Application No: R/94/25/HH  
Site Address: Seascape 5 West Mead Rustington BN16 2SL  
Description of works: Removal of existing flat roof garage and replacement with a pitched roof extension, new attached double garage and a detached car port. Alterations to existing fenestration. Roof alterations including amending the existing rear shed dormer to a flat roof dormer and the front facing shed dormer to a gabled dormer plus incorporation of rooflights.

Thank you for your internet representation made on 7th July 2025 which has been recorded as an objection with the comments as follows:

Proposed South and West Elevations

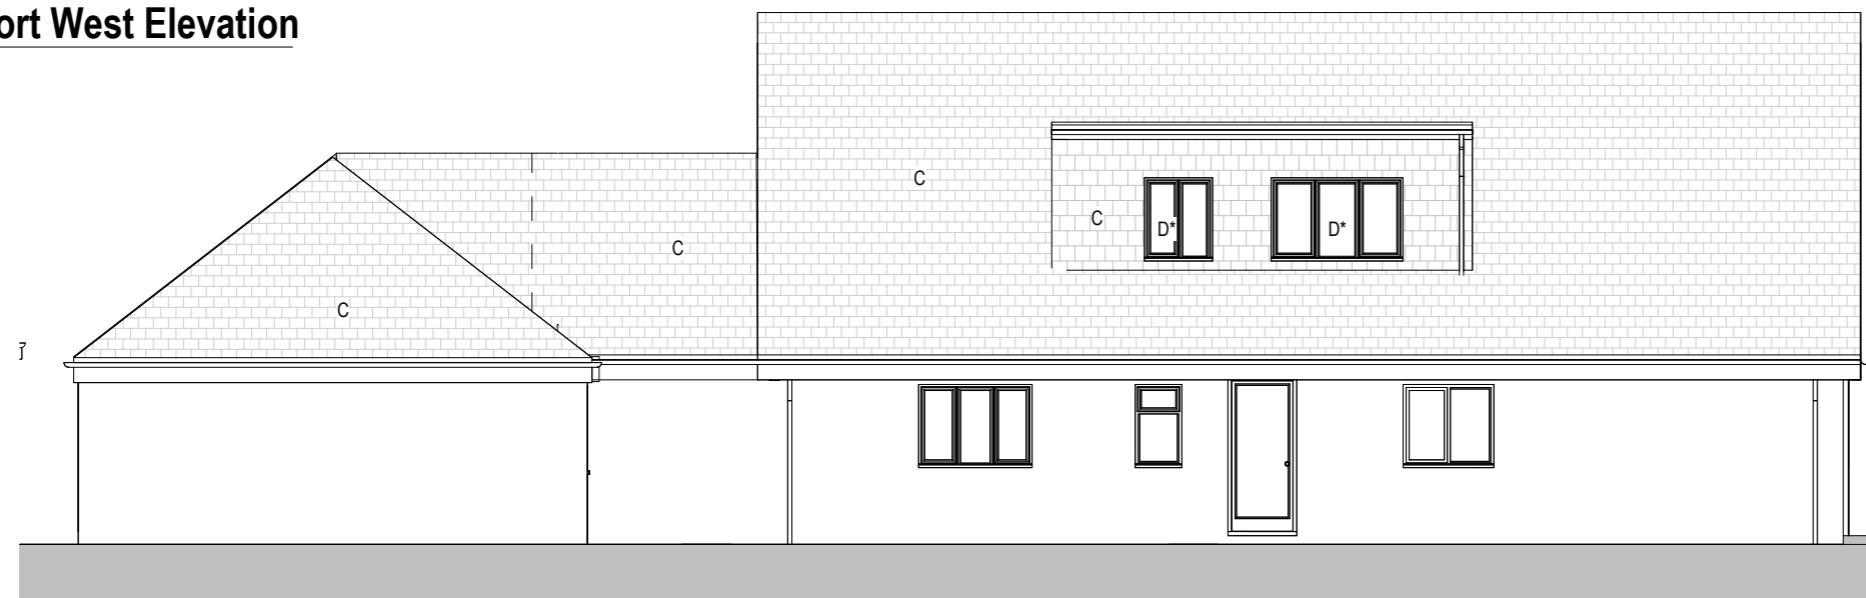
West facing dormer extension increases the number of windows and size of window. This increases the glass area facing onto our rear garden and our east facing rooms of our house. Also these being bathroom windows we would wish to ensure the minimum view from our garden into a bathroom. The dormer replacement and/or extension is a significant increase in size which will dominate the view and of us being overlooked.
